Online Comment

Application H11-0780-23
Location 12 PARK LANE LONG SUTTON SPALDING PE12 9DH
Proposal Proposed conversion of dwelling into 1 new house and 2 new flats

Name Jim Bonnor
Address Historic Places Team Lincolnshire County Council

FRONT

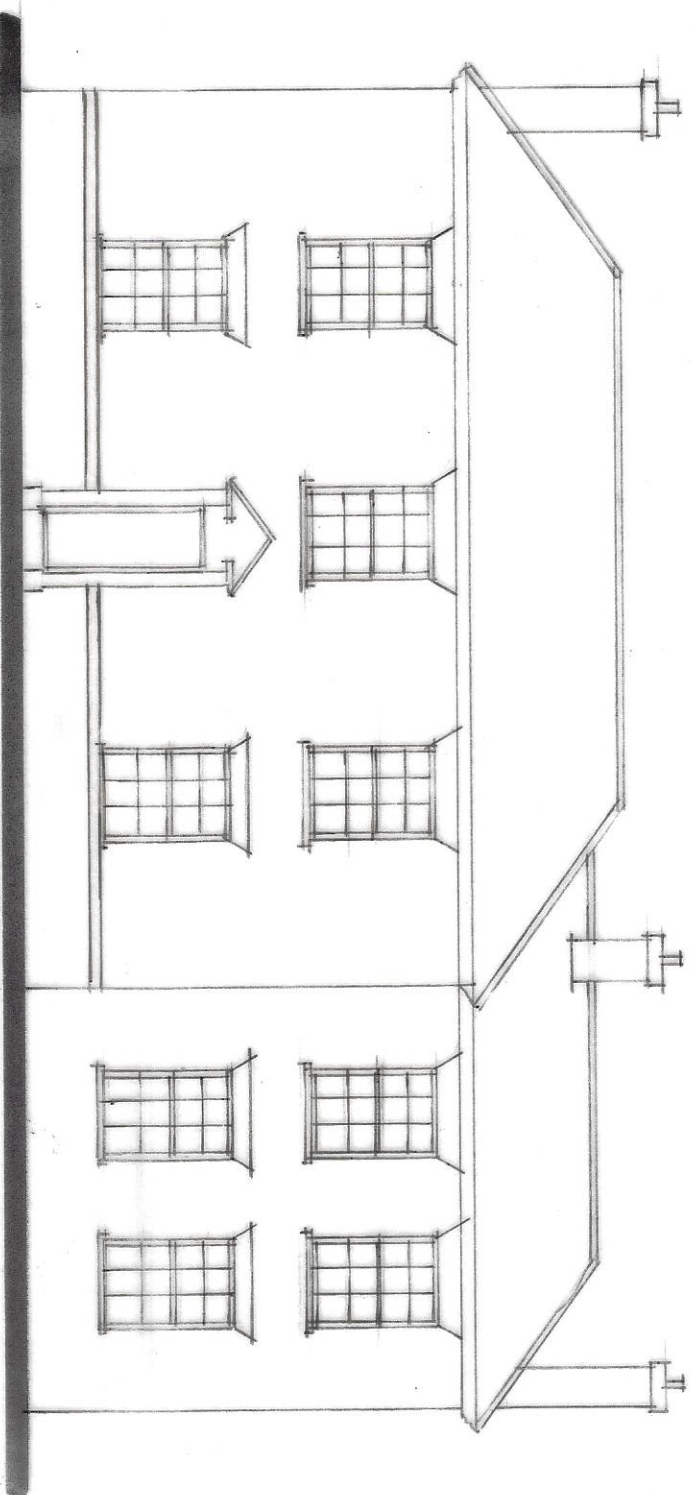
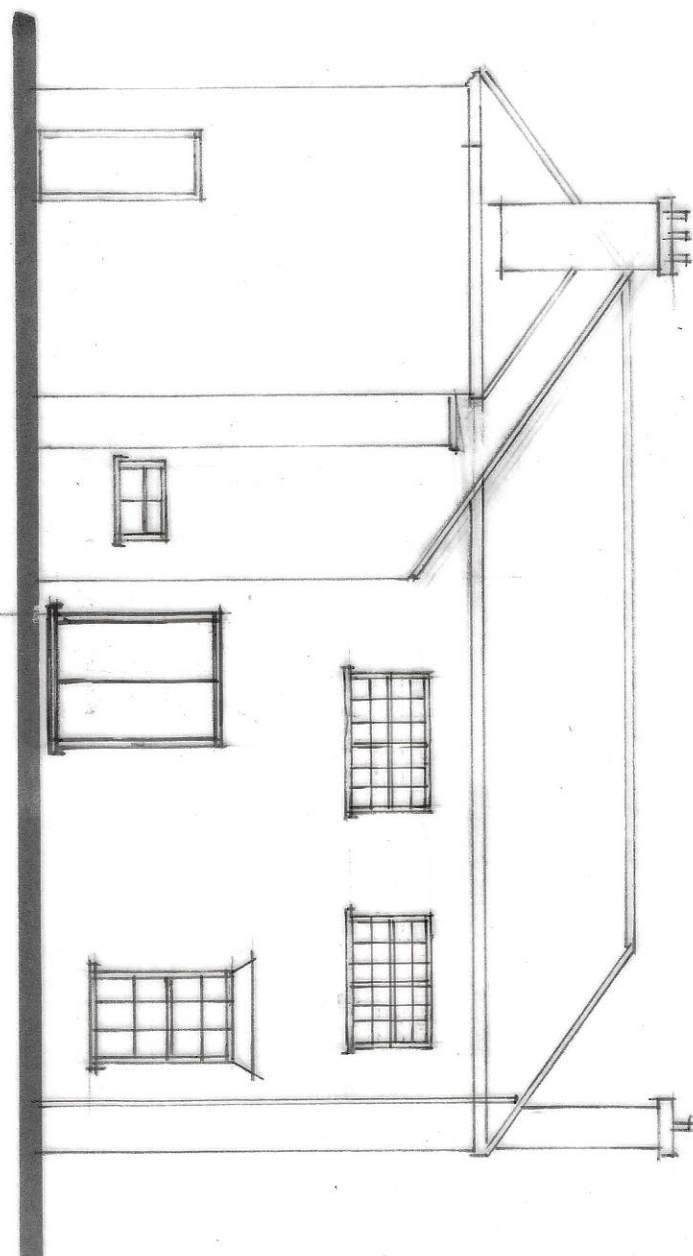
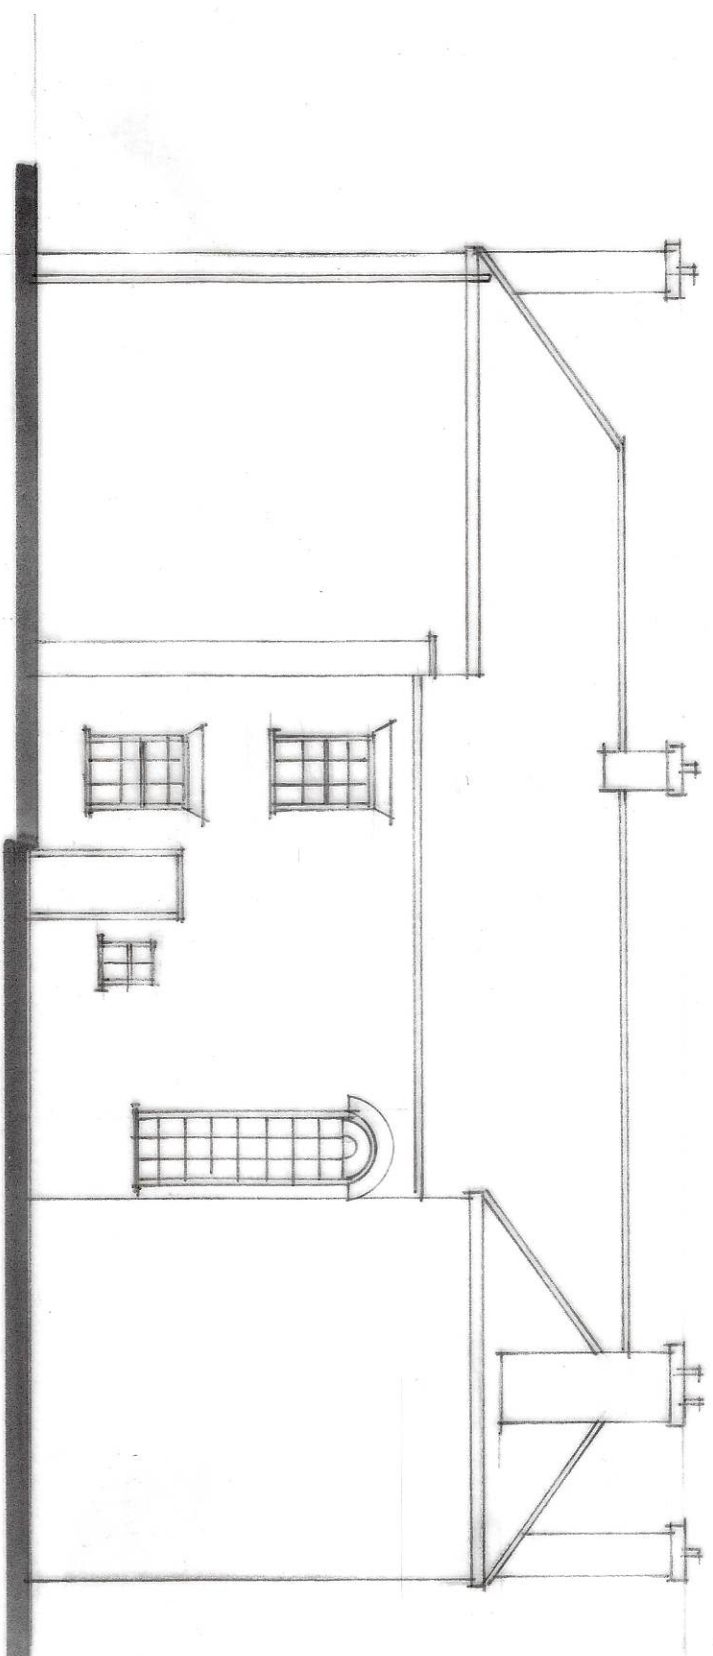
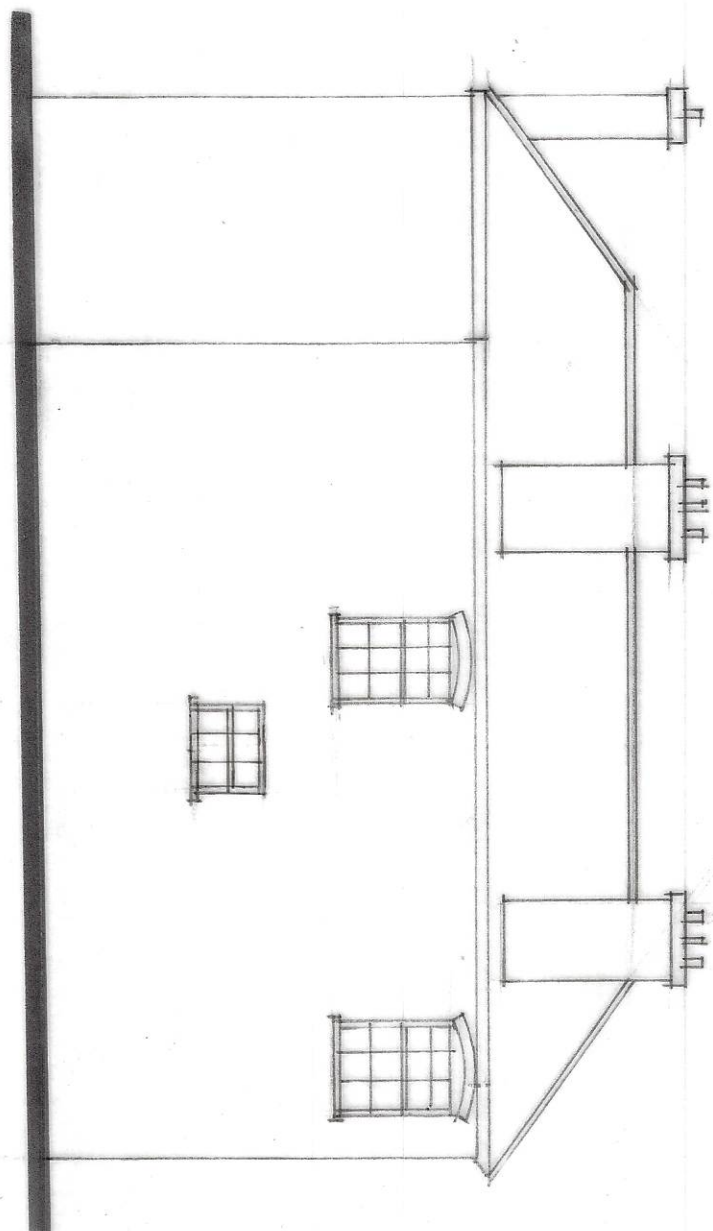
The proposed alterations involve the replacement of windows with non-traditional materials as well as the blocking up of doorways and creation of new openings, notably replacing an original window with French windows.

It is recommended that the applicant is required to submit a heritage statement which will identify the significance of the historic building and how any alterations to the historic fabric will affect that significance. It is suggested that the statement should include some historical and cartographic research, to demonstrate the development of the building, as well as photographs of the buildings elevations an interior to illustrate any historic fabric to be altered. This will enable the effect on the historic character of the building to be determined and whether any form of mitigation is required.
